**Application for a non-material amendment following a grant of planning permission.  
Town and Country Planning Act 1990**

Two storey extension & alterations

H13-1055-19

FLOOR PLANS & ELEVATIONS - PROPOSED.
SITE PLANS.

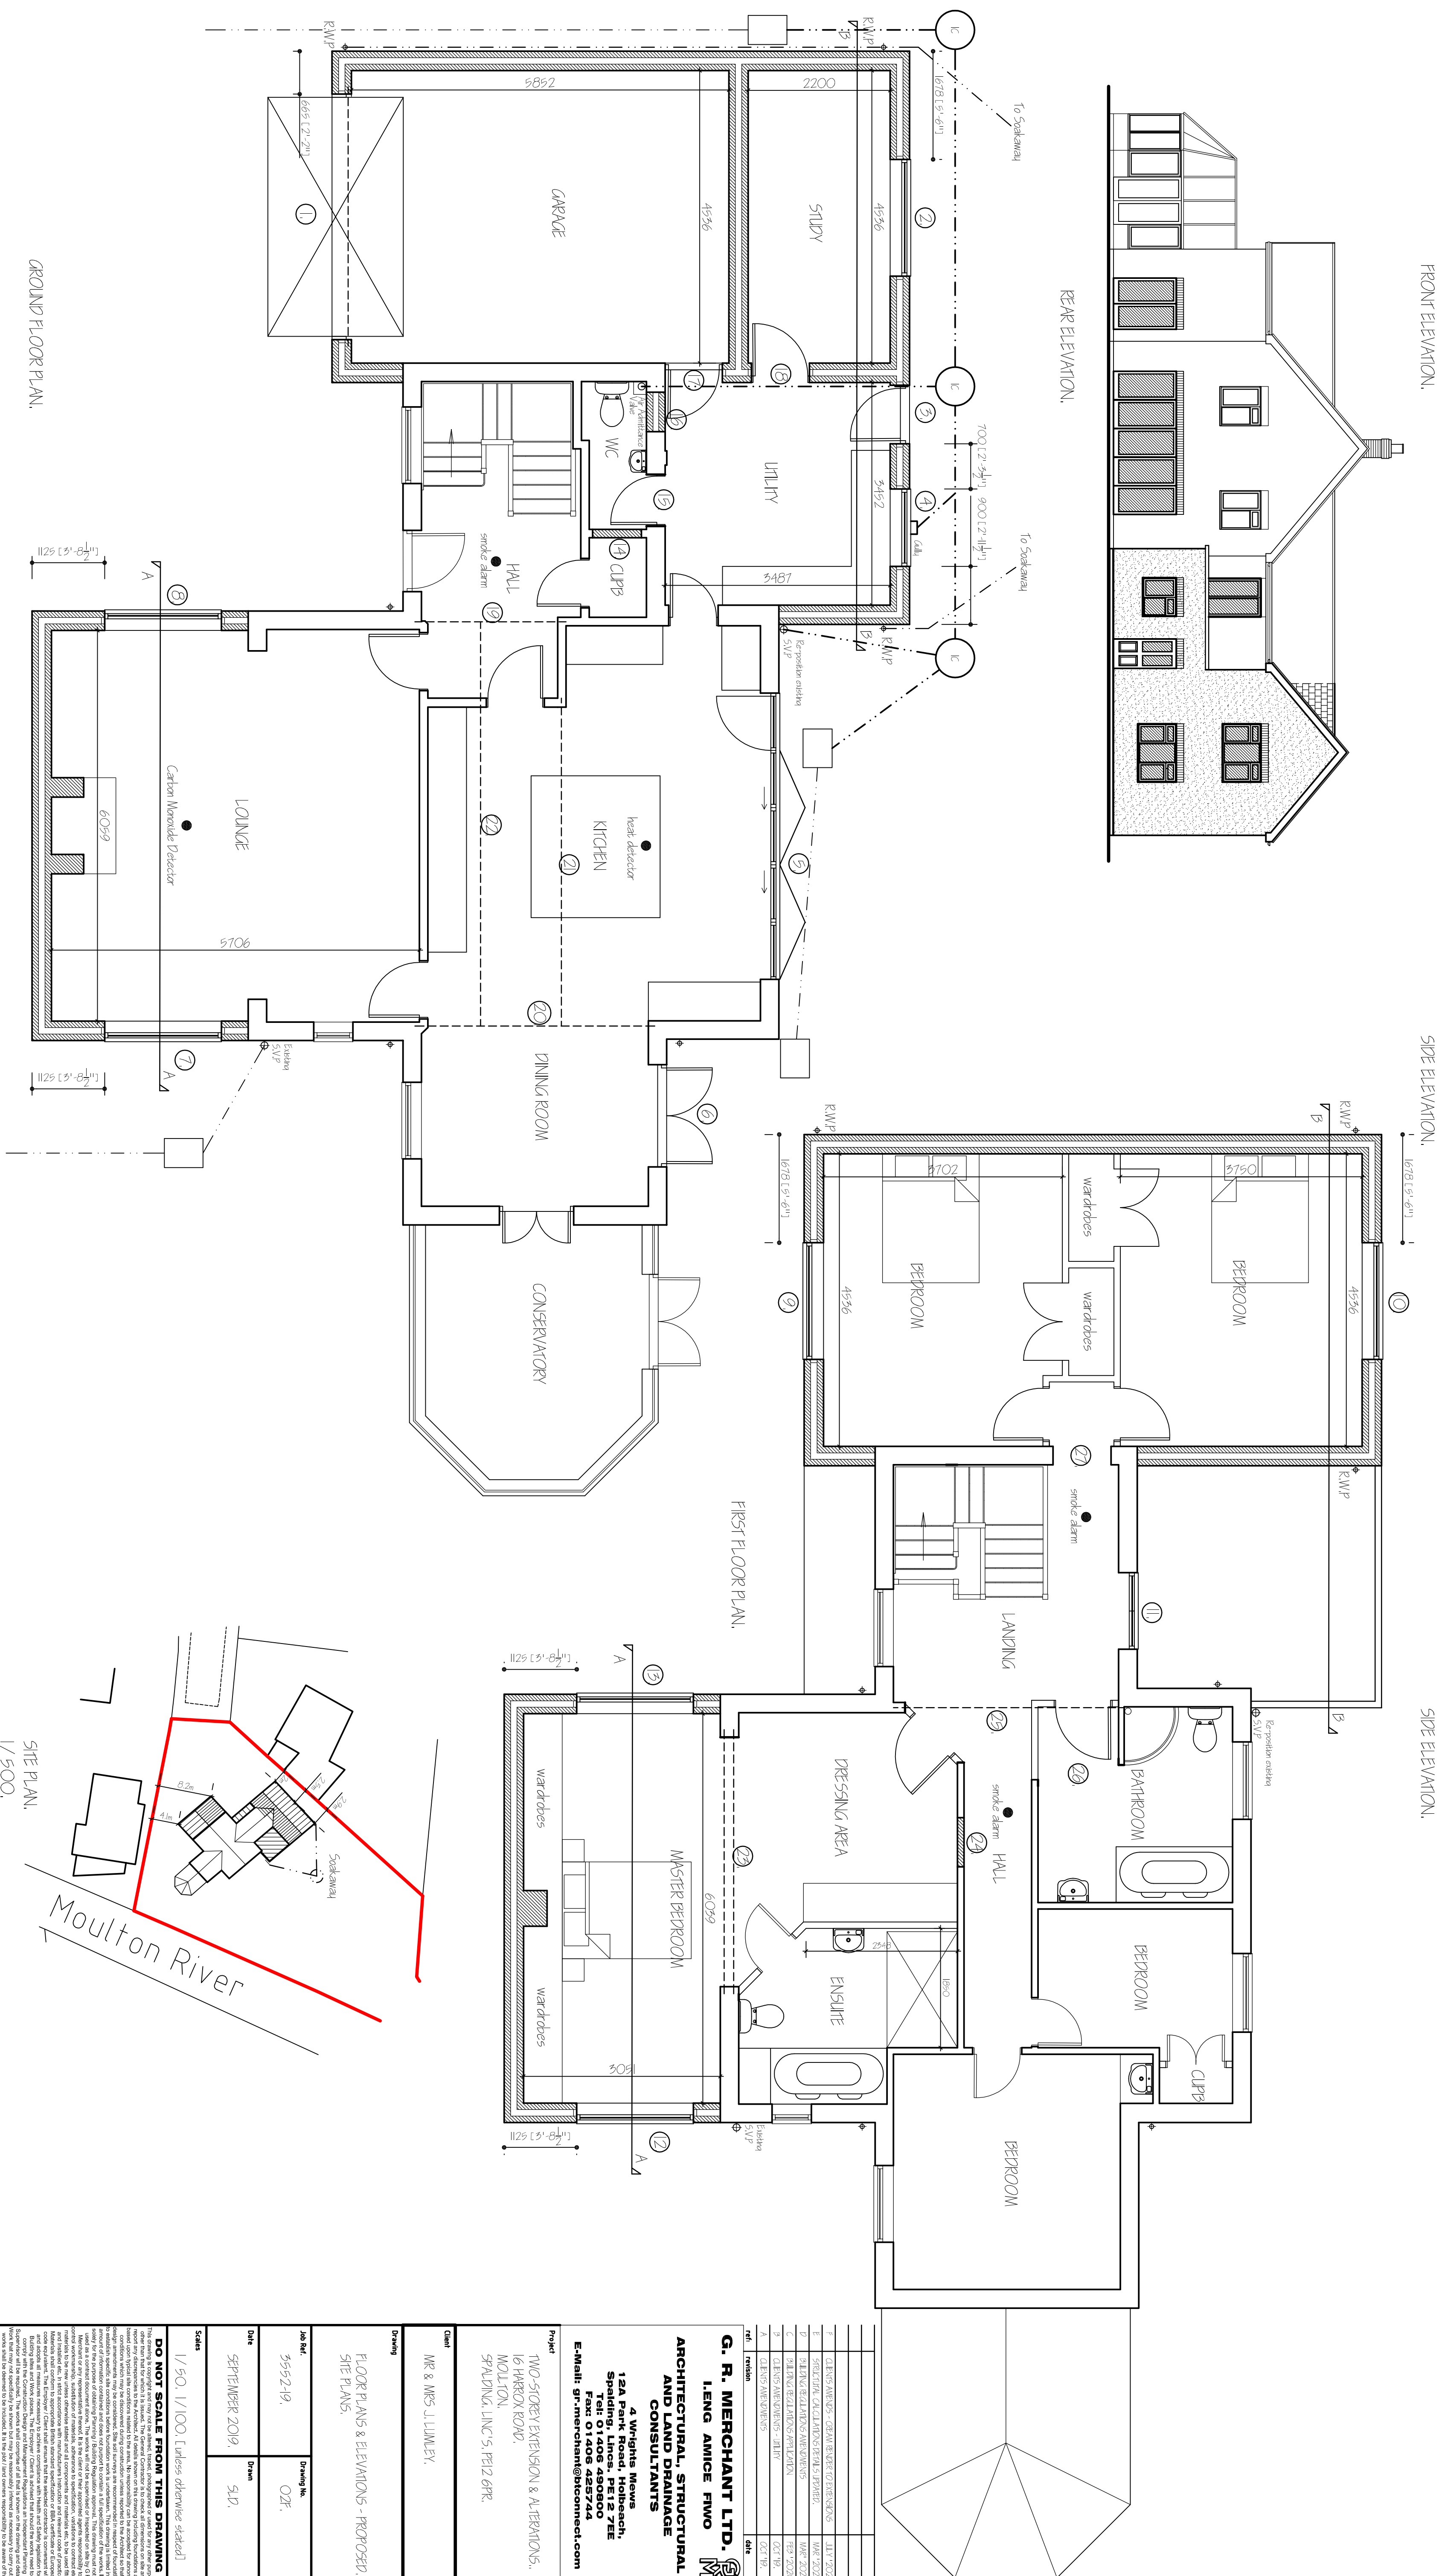
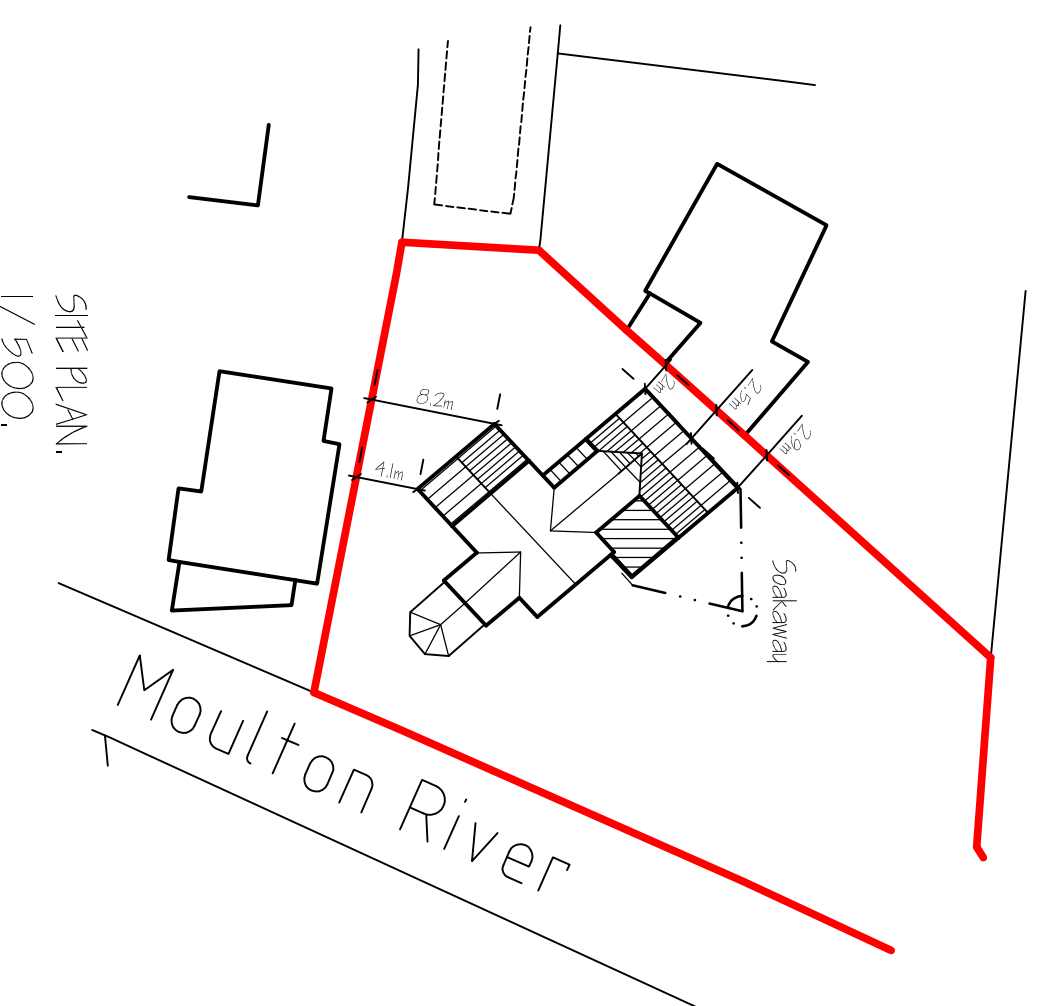
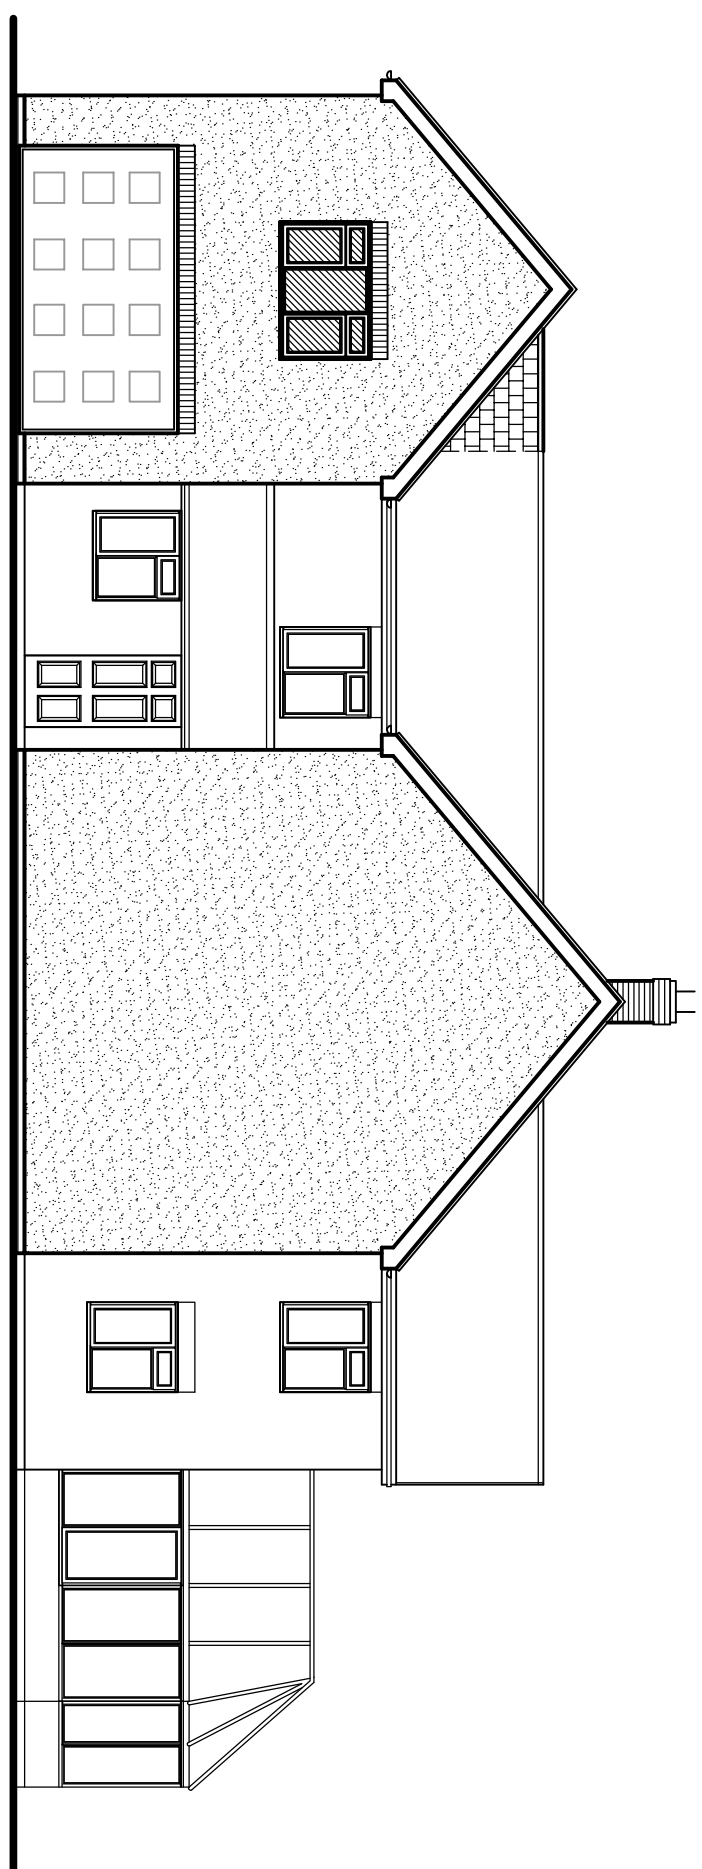
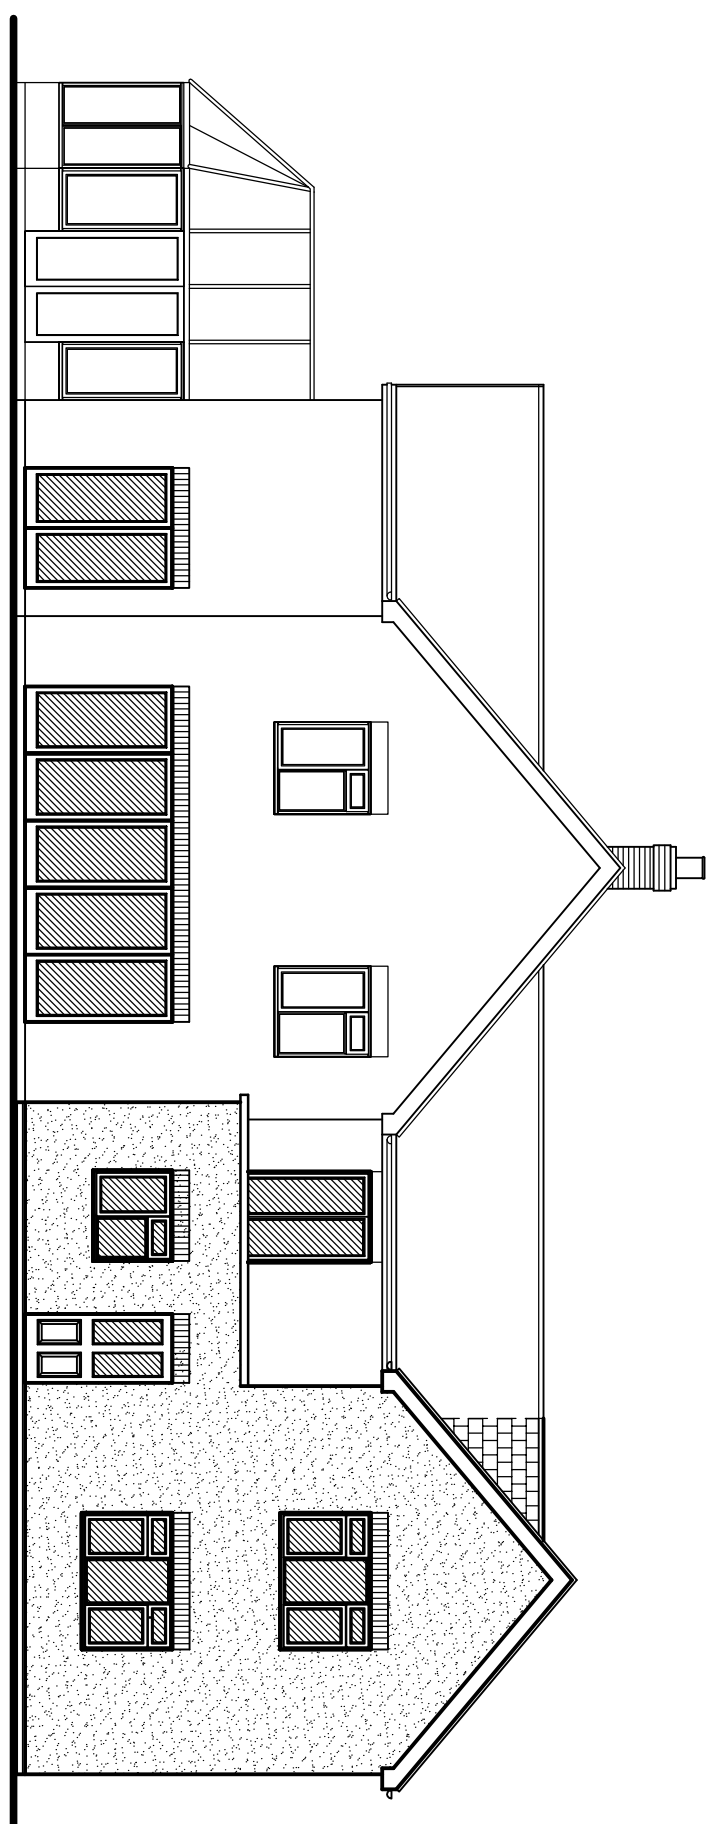
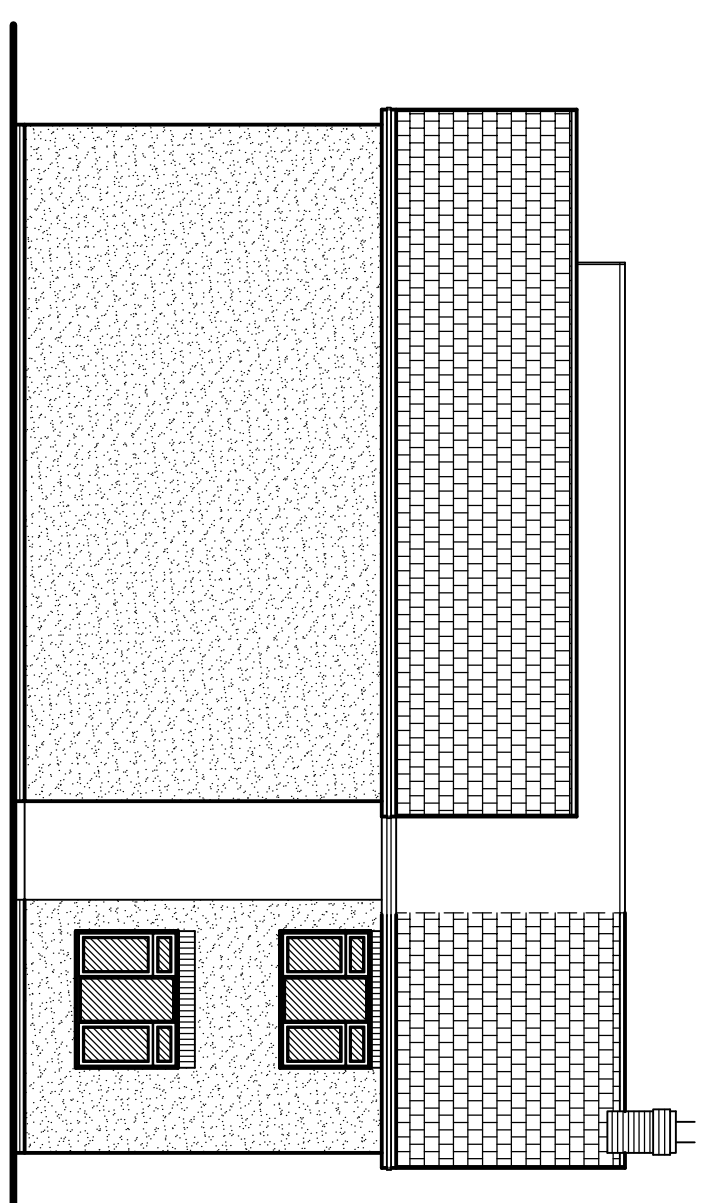
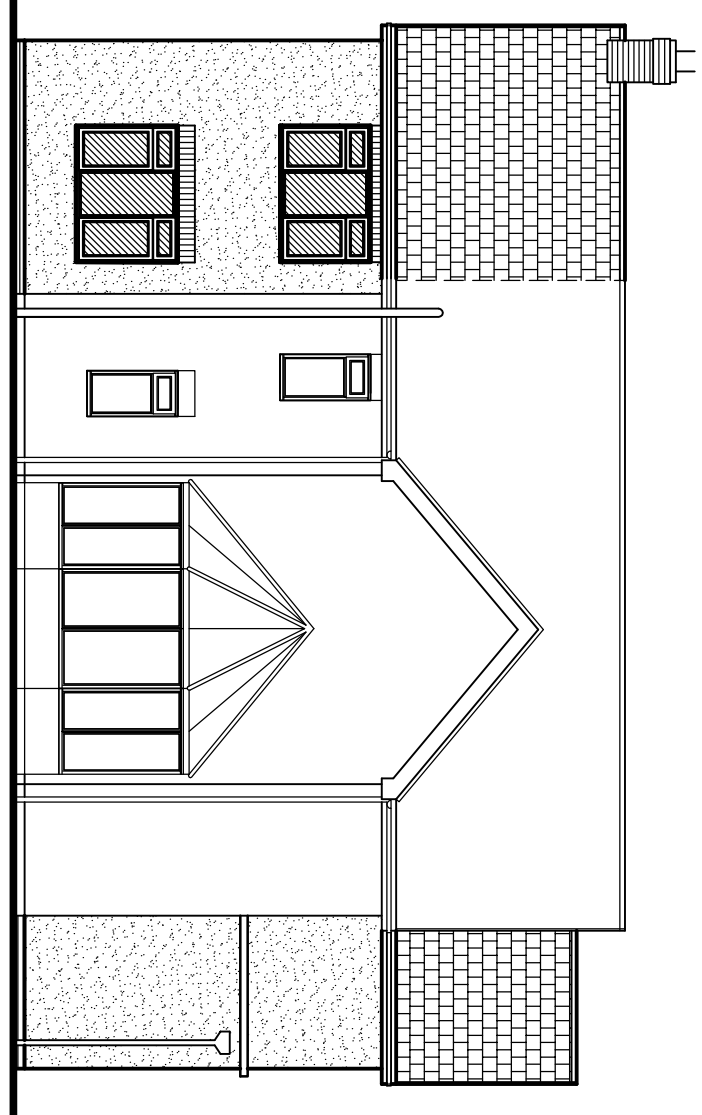
Te extensions to be cream render

Old plan/drawing number(s):

02B

New plan/drawing number(s):

02F
